**A1 IN NORTHUMBERLAND: MORPETH TO ELLINGHAM DEVELOPMENT
CONSENT ORDER (DCO): DEADLINE 4 SUBMISSIONS AND EXA WRITTEN
QUESTIONS.**

A1 IN Northumberland: Morpeth to Ellingham DCO Application Planning Inspectorate Reference: TR010059

Summary of Written Representations On behalf of the Environment Agency (EA)

Figure 1 - Stabilisation Works Location Plan

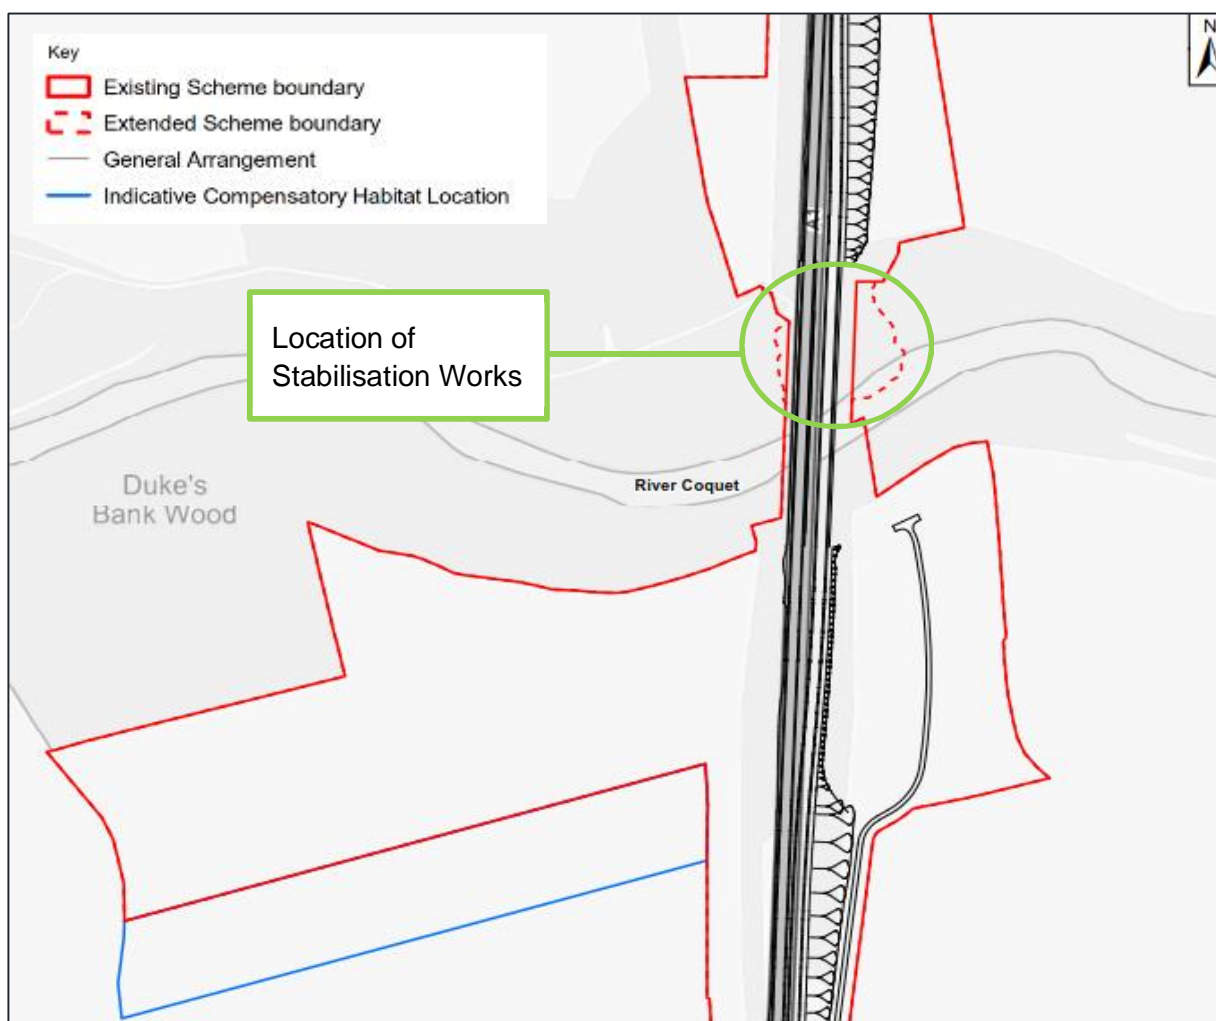
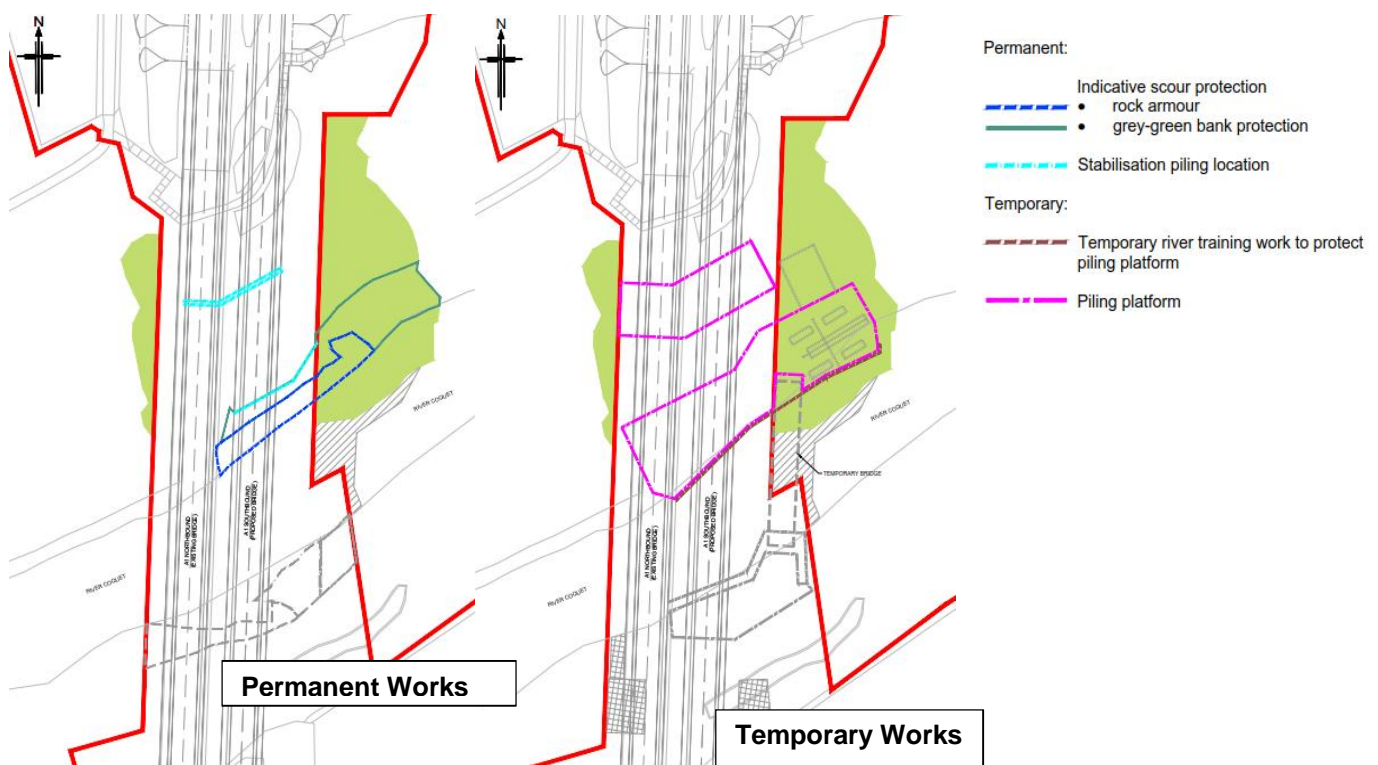
The Applicant fails to address the local severe adverse effect of rock armouring, loss of natural riverbank which forms an important component of the HoPI and therefore fails to provide mitigation or compensation. The current mitigation only reflects the loss of broadleaved woodland, and does not acknowledge the riparian zone which is being lost and is classed as a different habitat type with different functions and value that is likely found on the banks and around the wetted channel. This is a quality element and therefore a key consideration under the Water Framework Directive (WFD).

The proposals associated with the stabilisation works and southern access will decouple the slopes from the channel, thereby preventing the processes described above from happening. They will also significantly restrict how the channel responds if any of these slope process occur up or downstream of the rock armoured reach.

The rock armour, will permanently fix the river channel and bed in its current position. The slope stabilisation piles will decouple the channel from the gorge sides, thereby preventing the supply of sediment to the channel. Flow and channel features will become these varied, thereby reducing the number and diversity of the species able to utilise the area. The proposals will also influence channel response and development beyond the footprint of the works (both up and downstream), thereby extending the potential range of deterioration.

**Appendix F - Proposed Woodland and Marginal  
Planting Plan (Part A and B)**

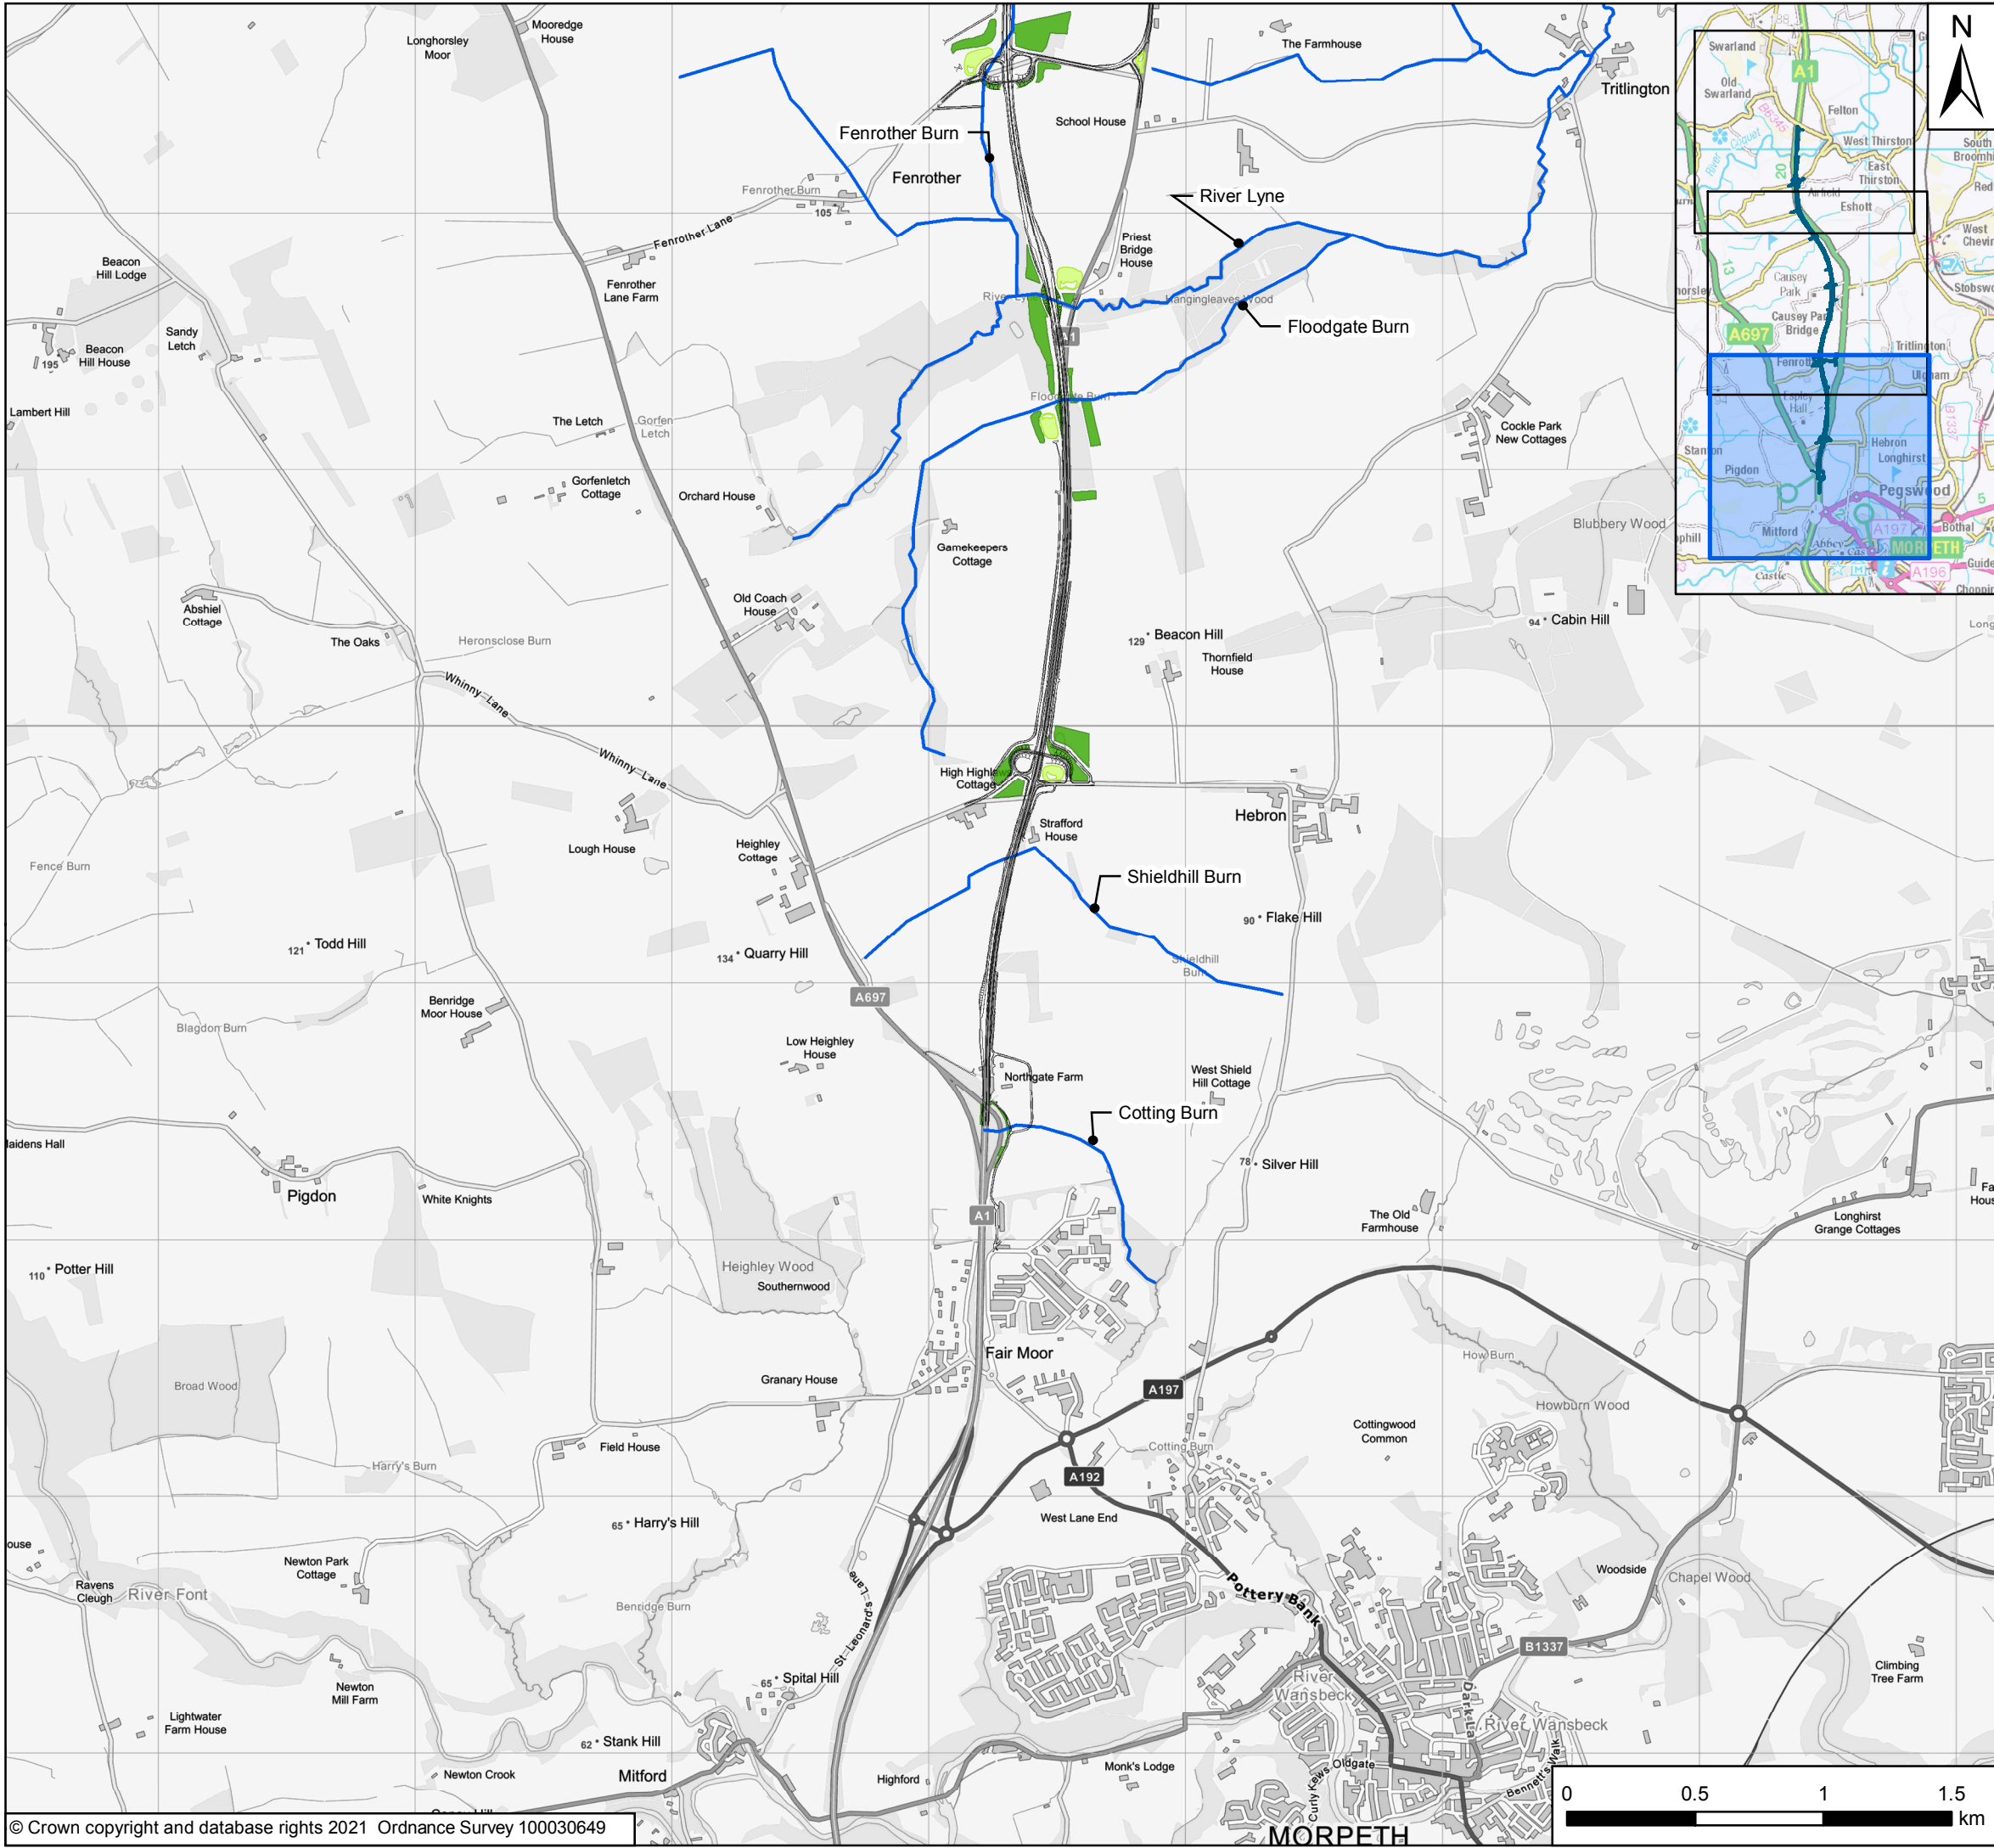
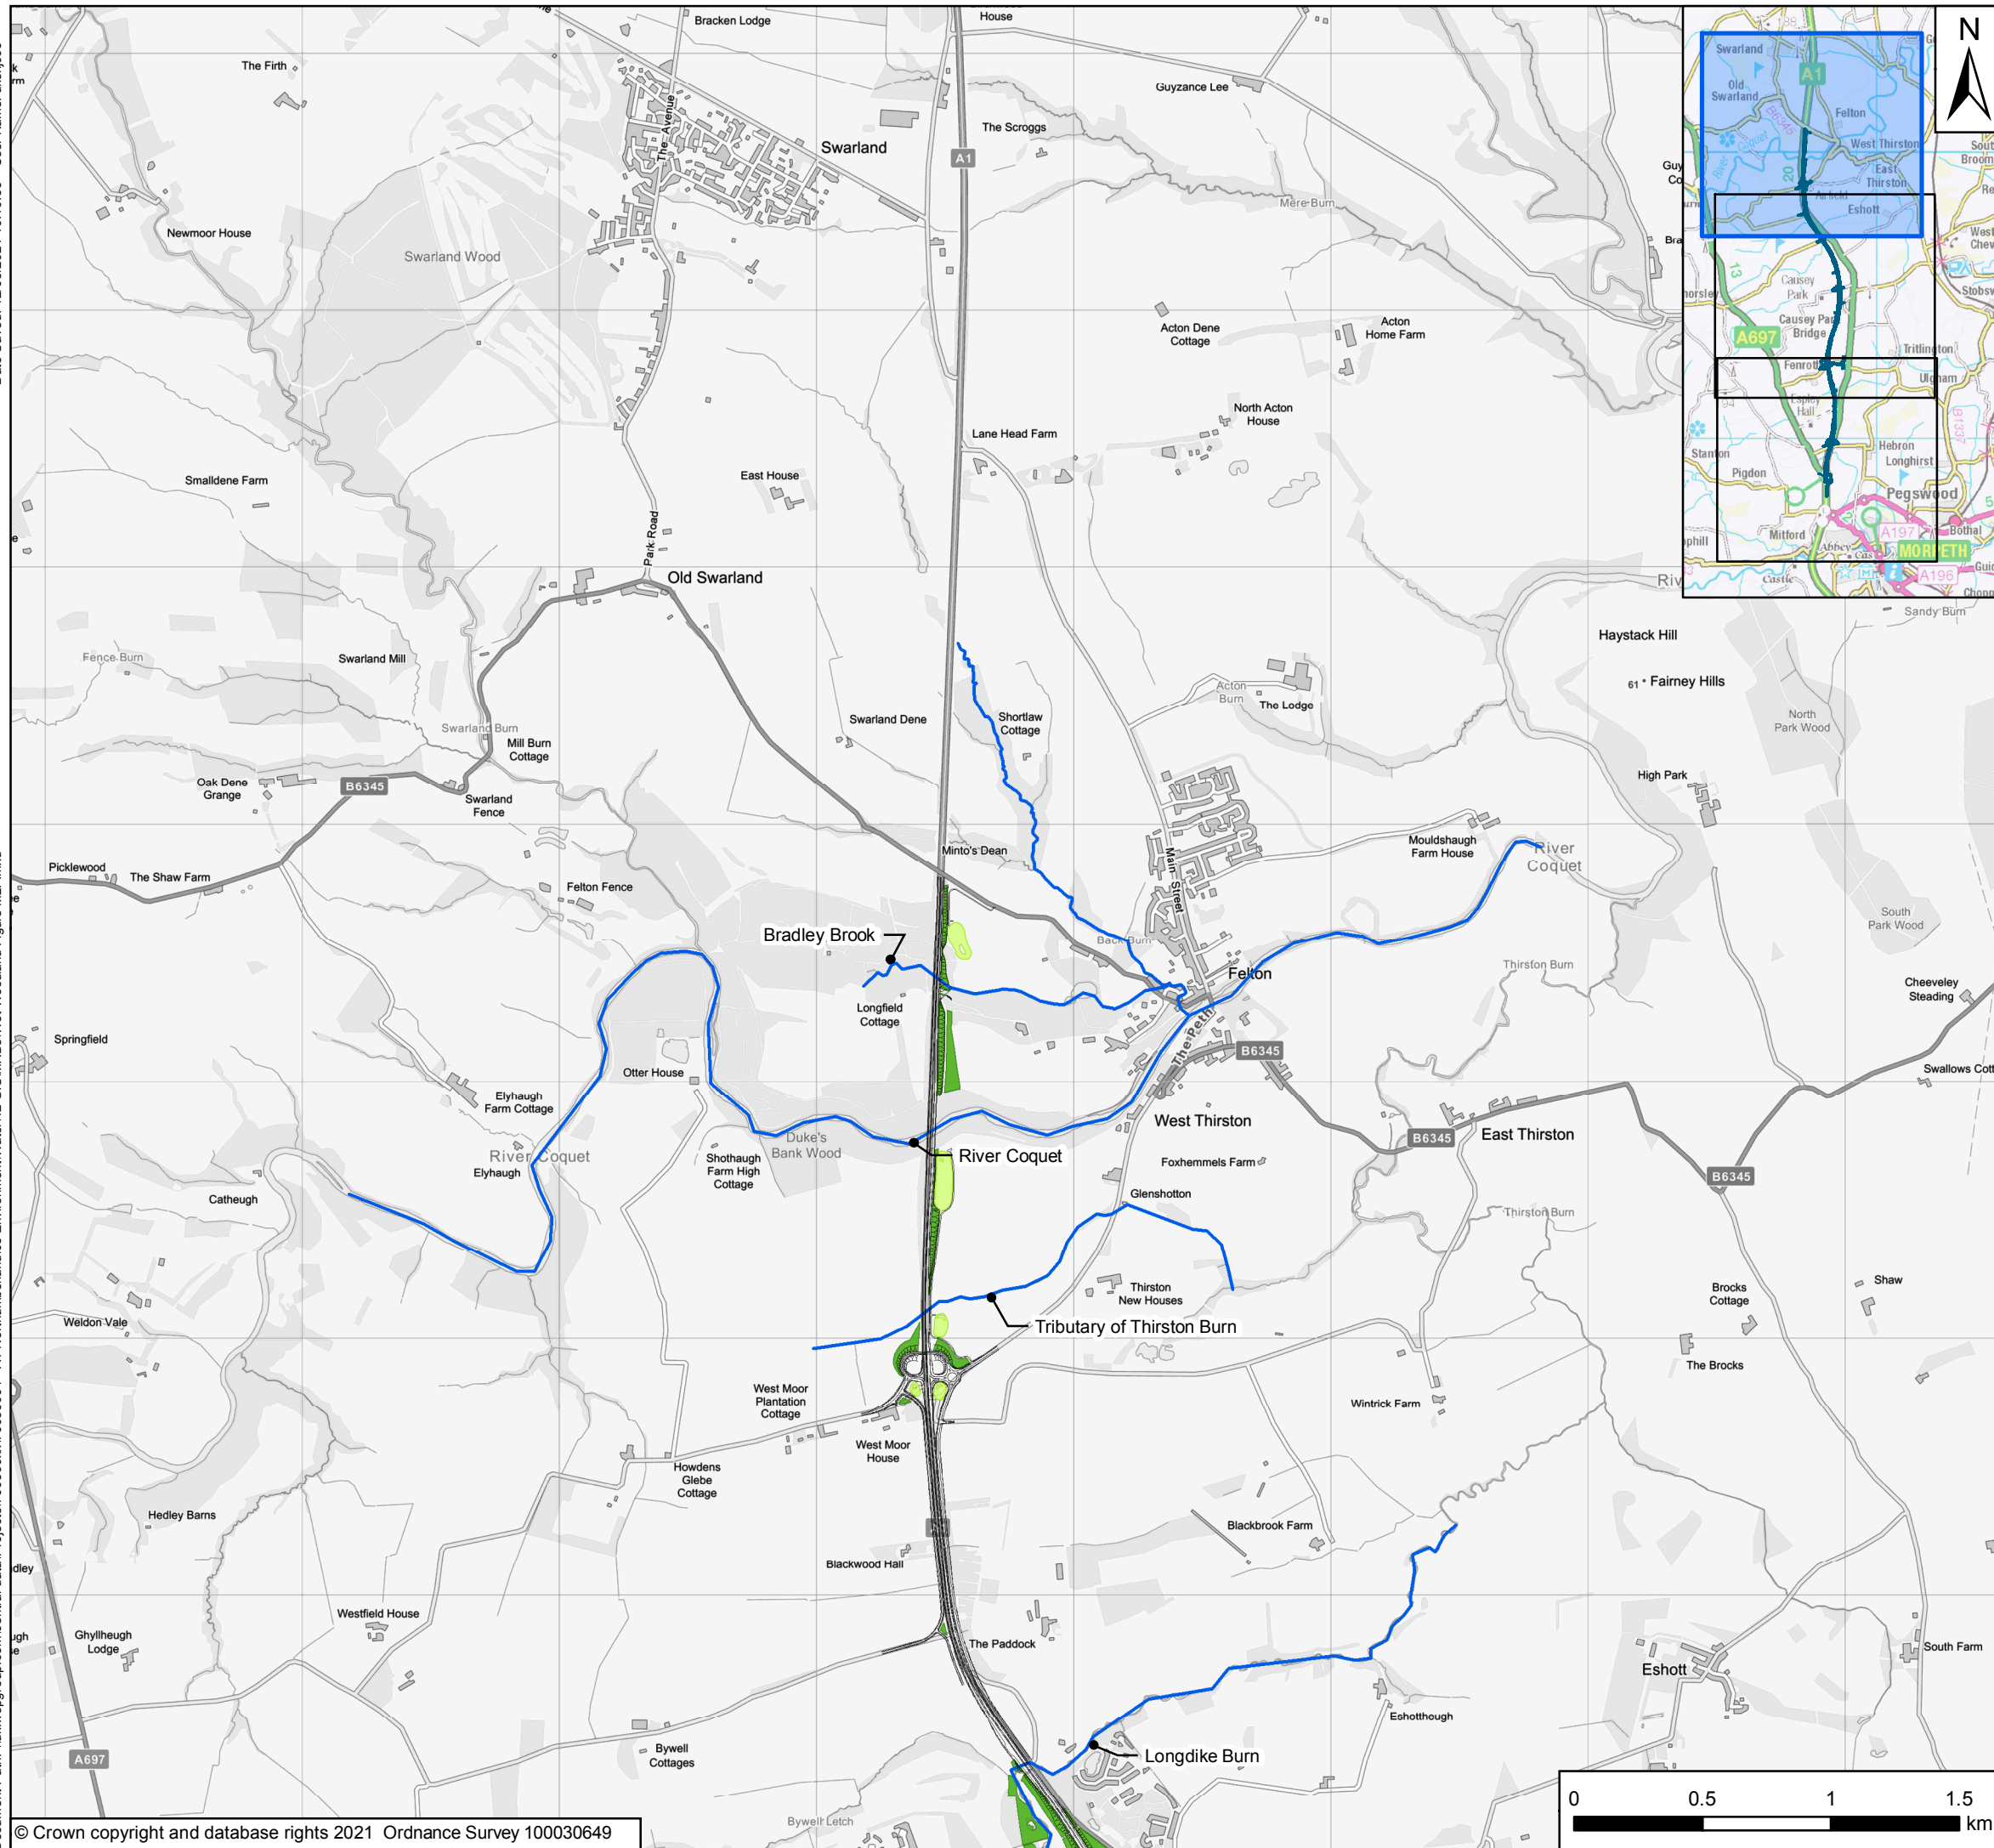
Deadline 4 Submission - 7.17.6 Written Summaries of the Applicant's Oral Submissions to Hearings: Appendix F - Proposed Woodland and Marginal Planting Plan (Part A and B) [REP4-031]

This clearly shows the vast majority of the woodland being planted as mitigation and compensation for the impact on the watercourse is neither 'wet woodland' as originally claimed nor riparian and is in fact broadleaf woodland. This habitat is not a water dependant habitat, has a different form and function and does not improve the watercourses affected by the scheme as the vast majority of this planting is disconnected from the watercourses. Therefore, we do not believe the proposals put forward by the Applicant adequately mitigates or compensates for the disturbance and damage to, and the loss of watercourses associated with the scheme.
